CHELWOOD APARTMENTS

REF: CERTIFICATION OF CHELWOOD APARTMENTS PHASE III (H22-D32)

REF: CERTIFICATION OF CHELWOOD APARTMENTS PHASE II (H22-D32)

Re: Chelwood Apartments Grading & Drainage Plan

REVISED GRADING & DRAINAGE PLAN & CERTIFICATION  
CHELWOOD APARTMENTS PHASES I, II & III

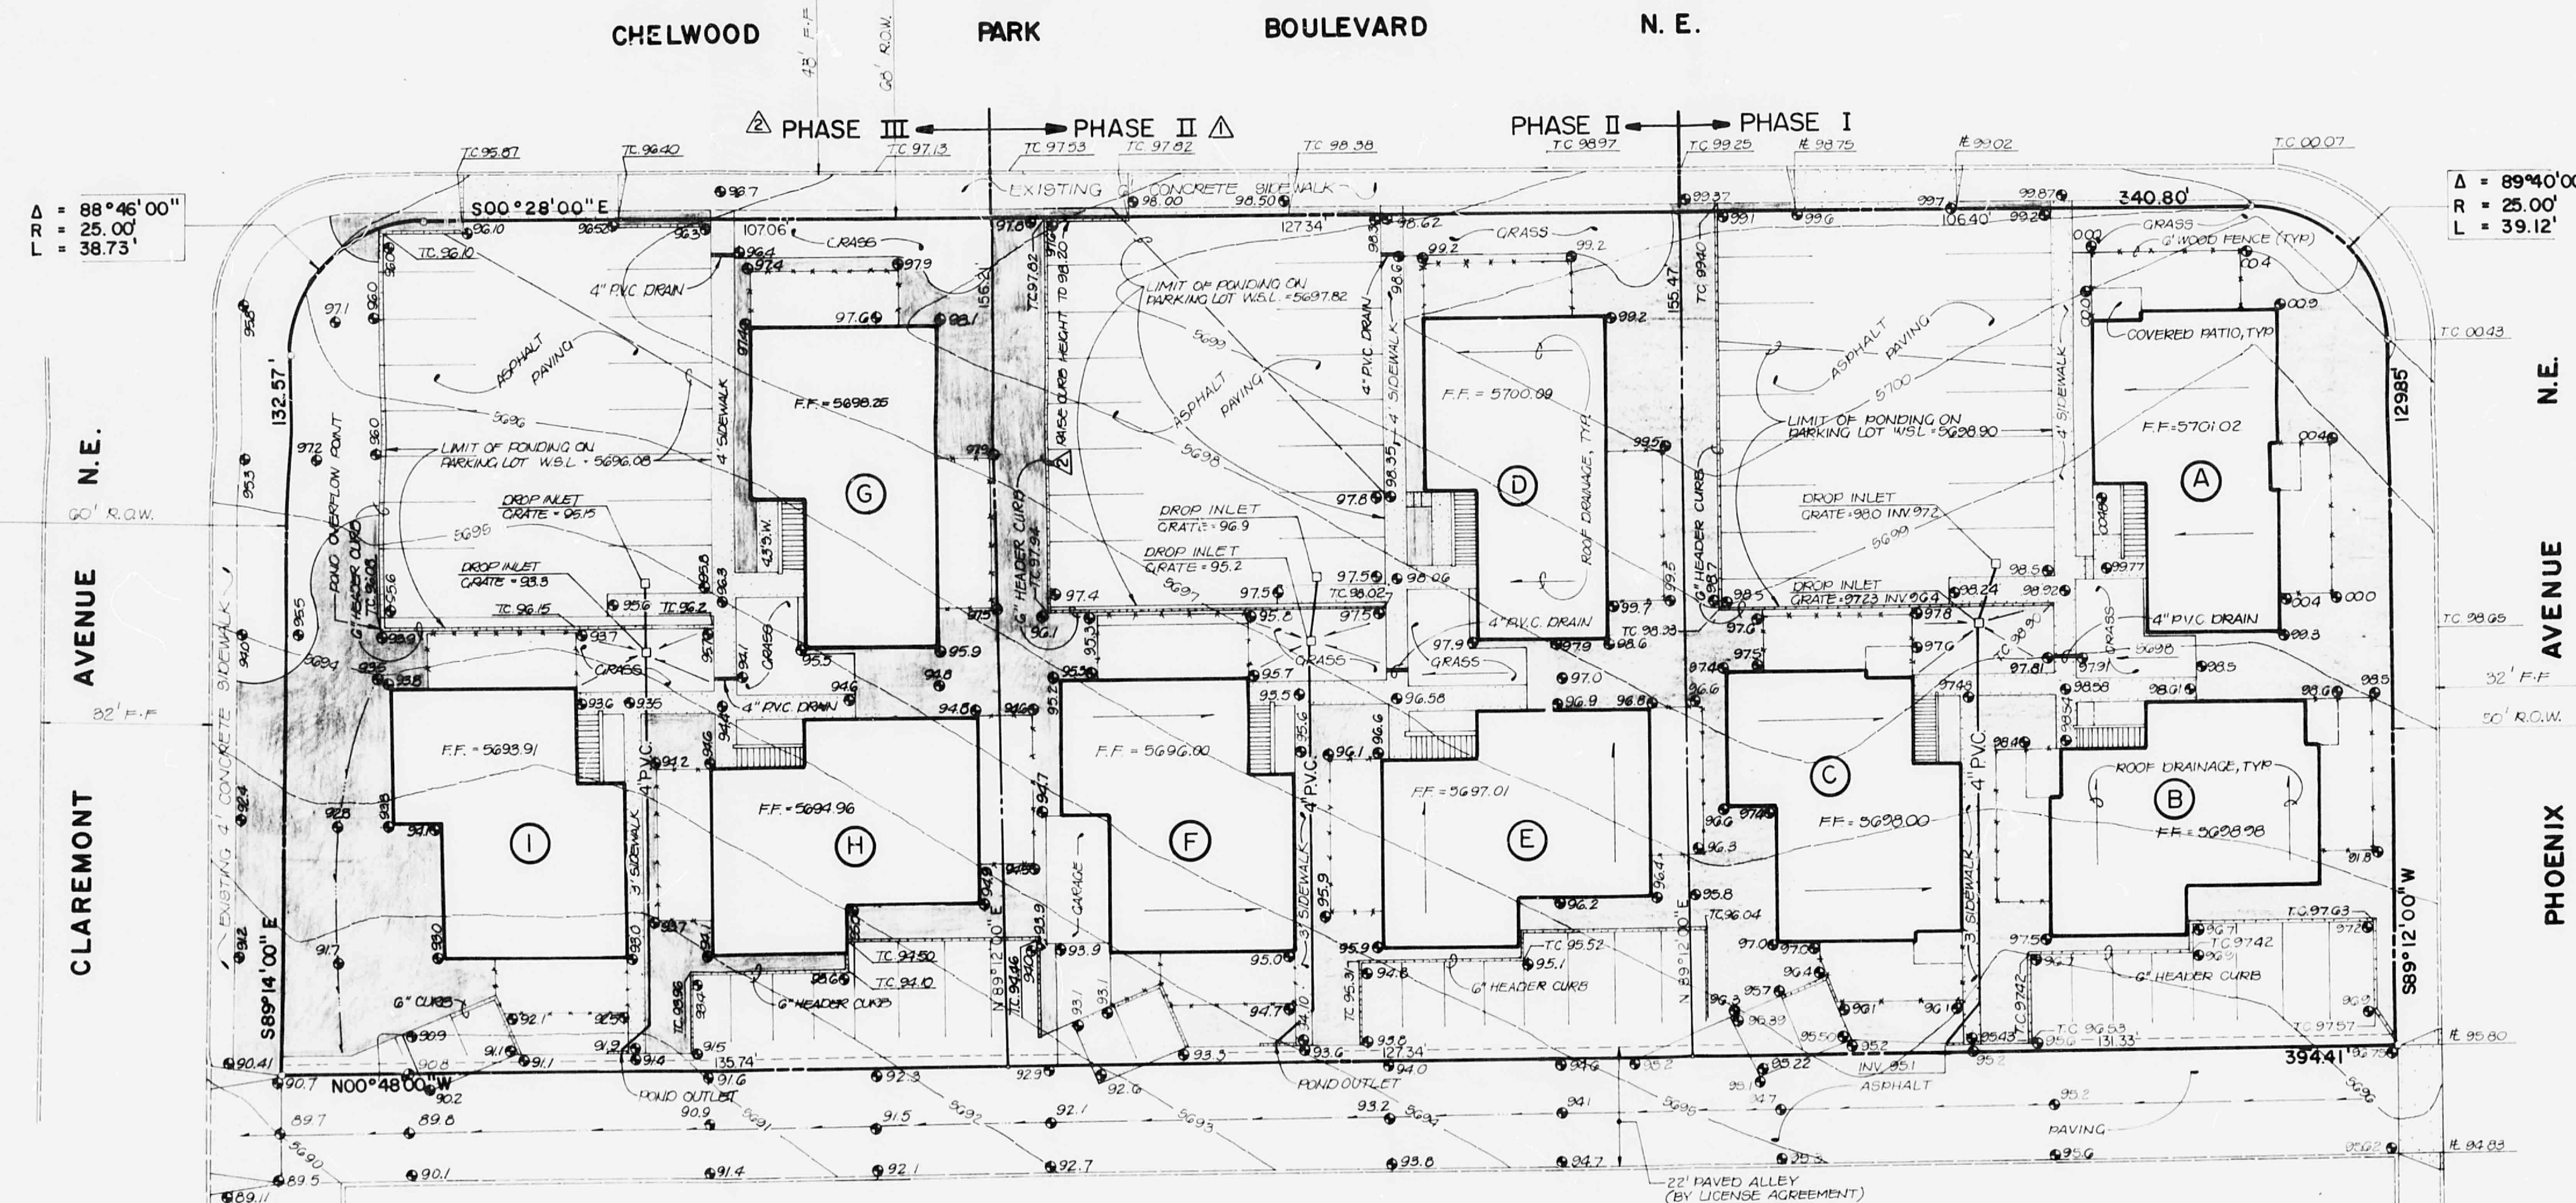
Based on the information provided on your March 13, 1984 submittal, the certification for the above referenced drainage plan is acceptable. Please advise your client, that upon completion of the revised curb on phase II they will need to provide me with a letter stating that they have completed the work to your specifications.

Based on the information provided on your February 21, 1984 submittal for certification of the above referenced site, the pond overflow point is shown to outlet over the public sidewalk. Normally we would like to see the overflow point exiting through a drivepad. Please advise your client that the perimeter curb will need to be raised at certain points to accomplish the overflow point at the drivepad. This revision will need to be completed before Phase III is released. Certification on Phase II is acceptable at this time, providing the above revisions are completed before Phase III certification is accepted.

This letter is to inform you that the revised curb on Phase II of the
above referenced project has been completed.
